September 5, 2023

Project Name / File No.: E Sunnyside PRD / PA22-033
Applicant: JM1 Holdings, LLC
Project Description: 27 Lot PRD-Subdivision
Re: Response to 1st Review Comments

This letter serves as the Applicant's formal response to the 2nd review comments received on March 20, 2023, to our recent application materials submitted to the City of Marysville. To ensure that each of the comments have been responded to, we have incorporated each of the City's comments along with the Applicant's response to each below.

DRAWING TITLE:
LANDSCAPE PLAN

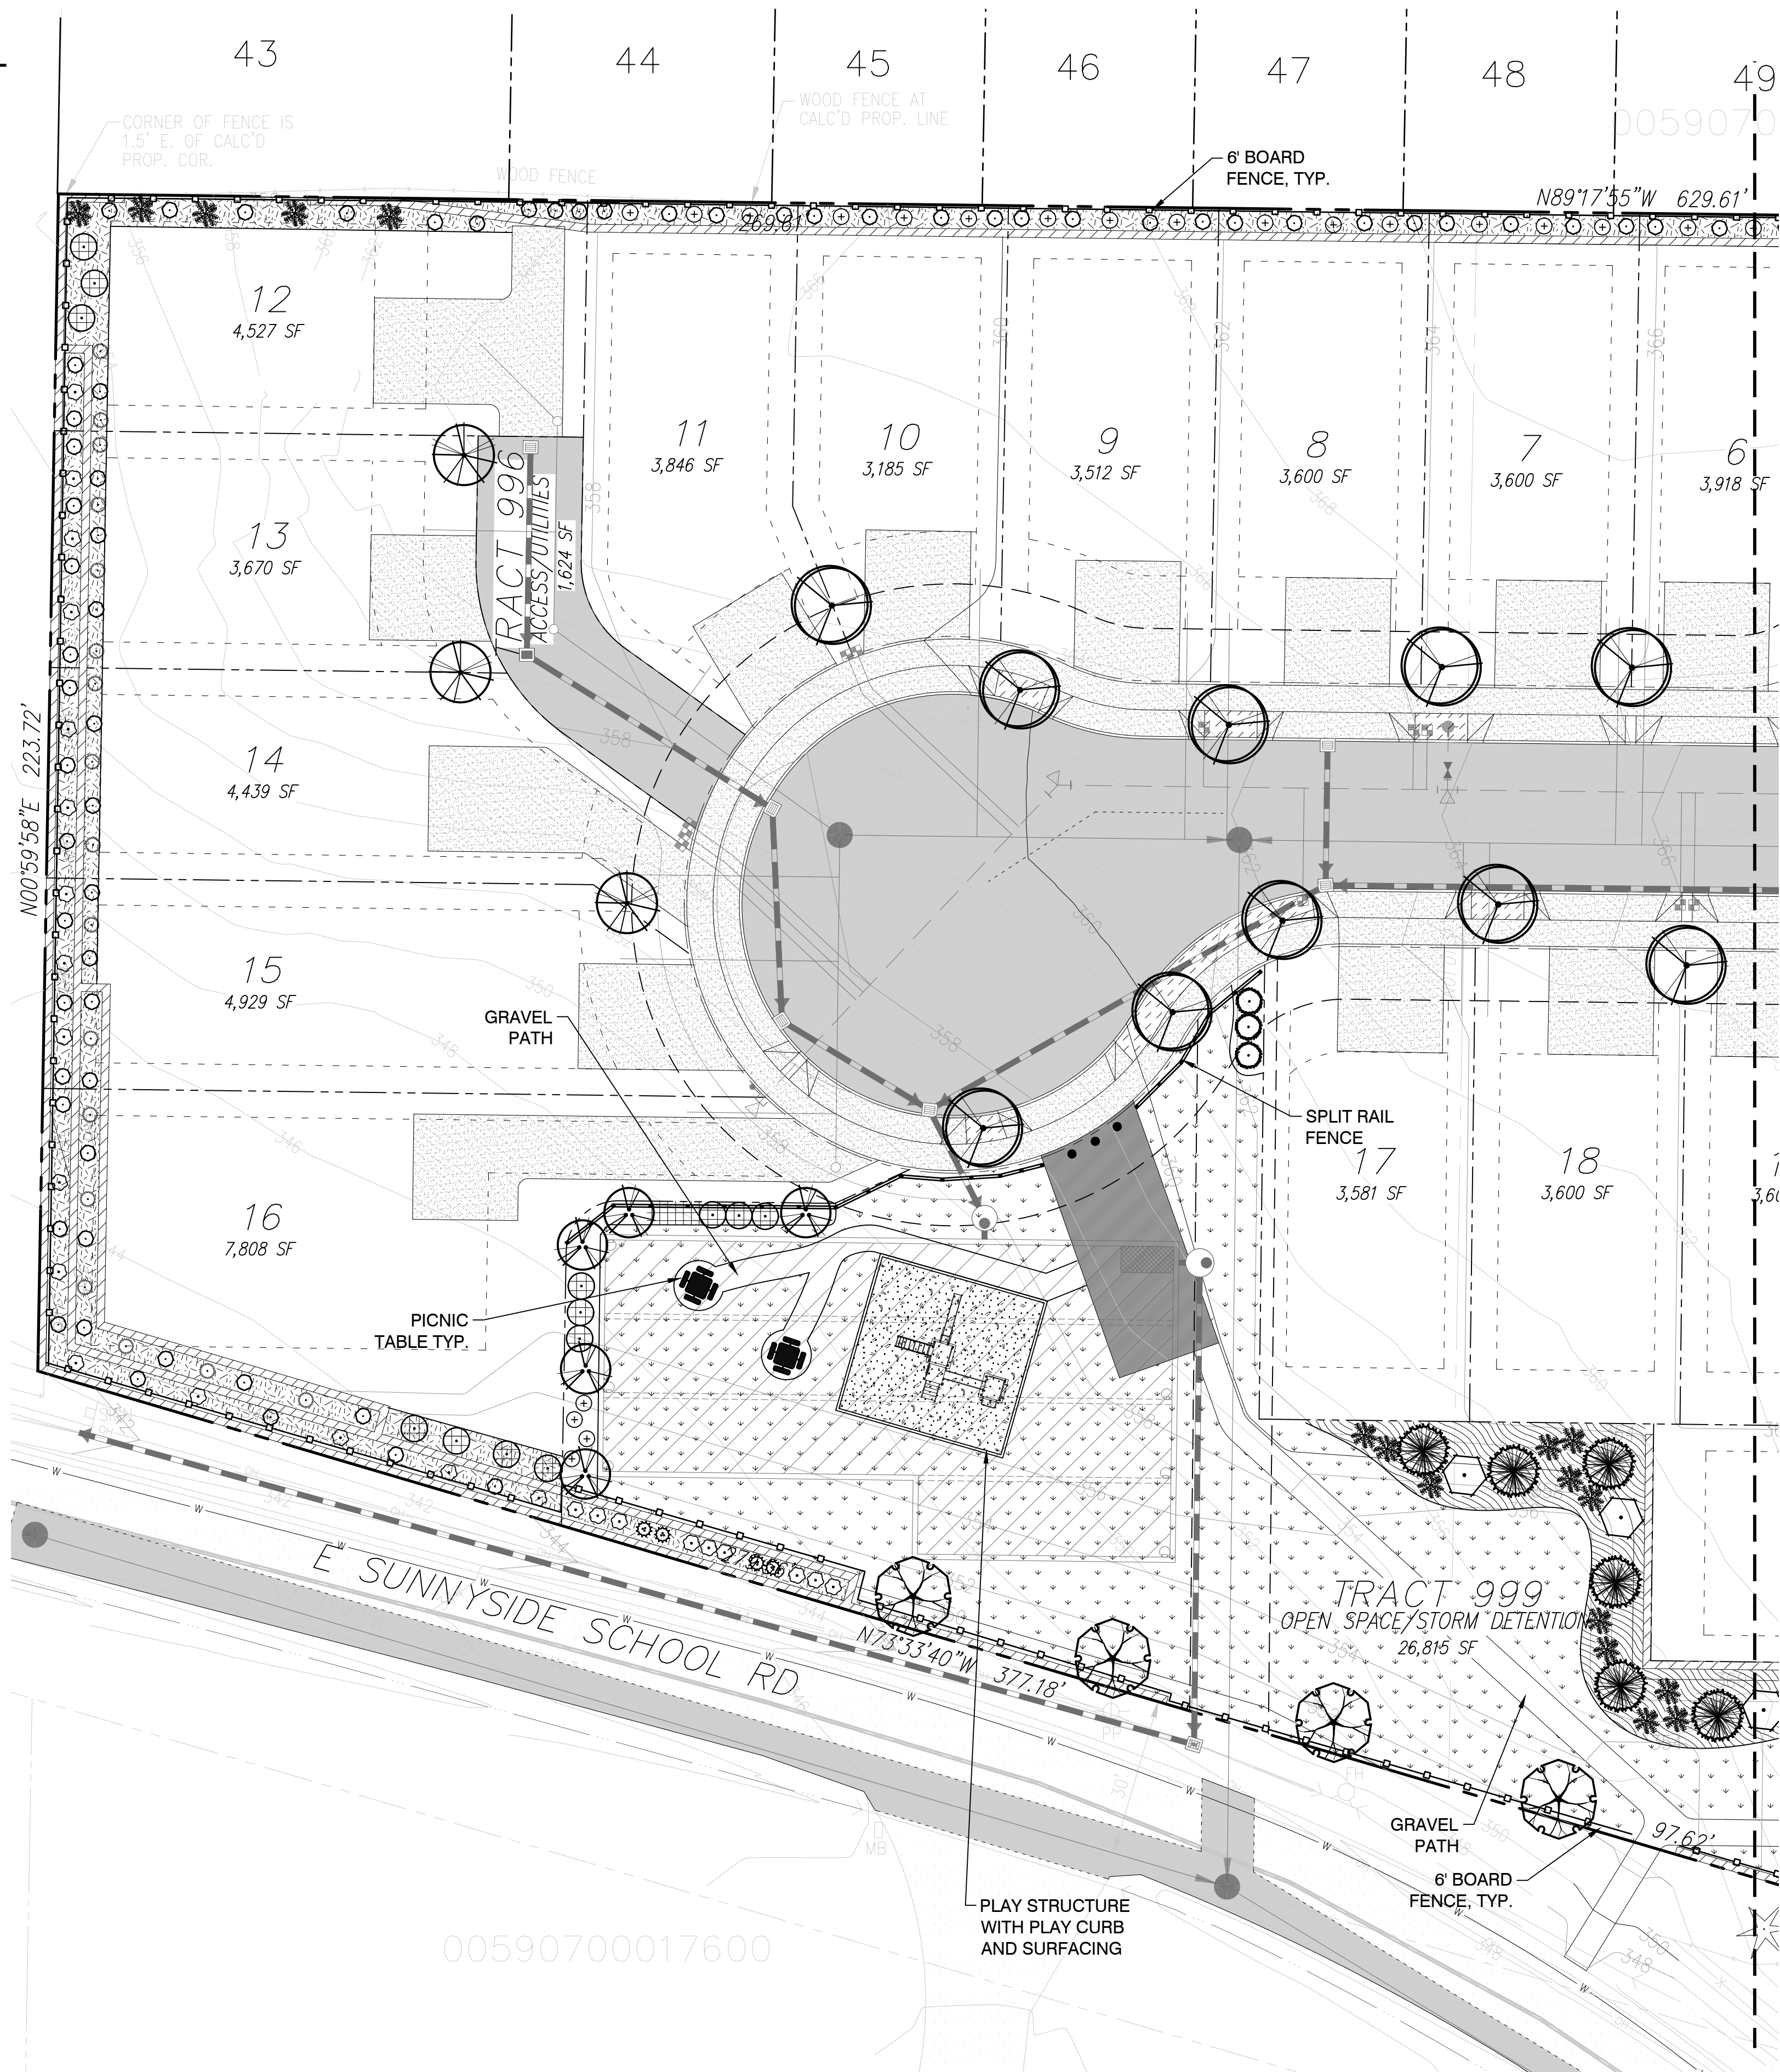
16. A portion of the RDI benefit on Lot 28 providing access to APN 005490700017503 would also not qualify. This will need to be removed from Sheet L2.

18. Continue a similar 5-foot landscaping buffer provided on the west side of the open space tract around the perimeter of the open space tract.

Applicant's Response: RDI credits are no longer being requested.

Applicant's Response: Perimeter landscaping has been provided for the open space tract.
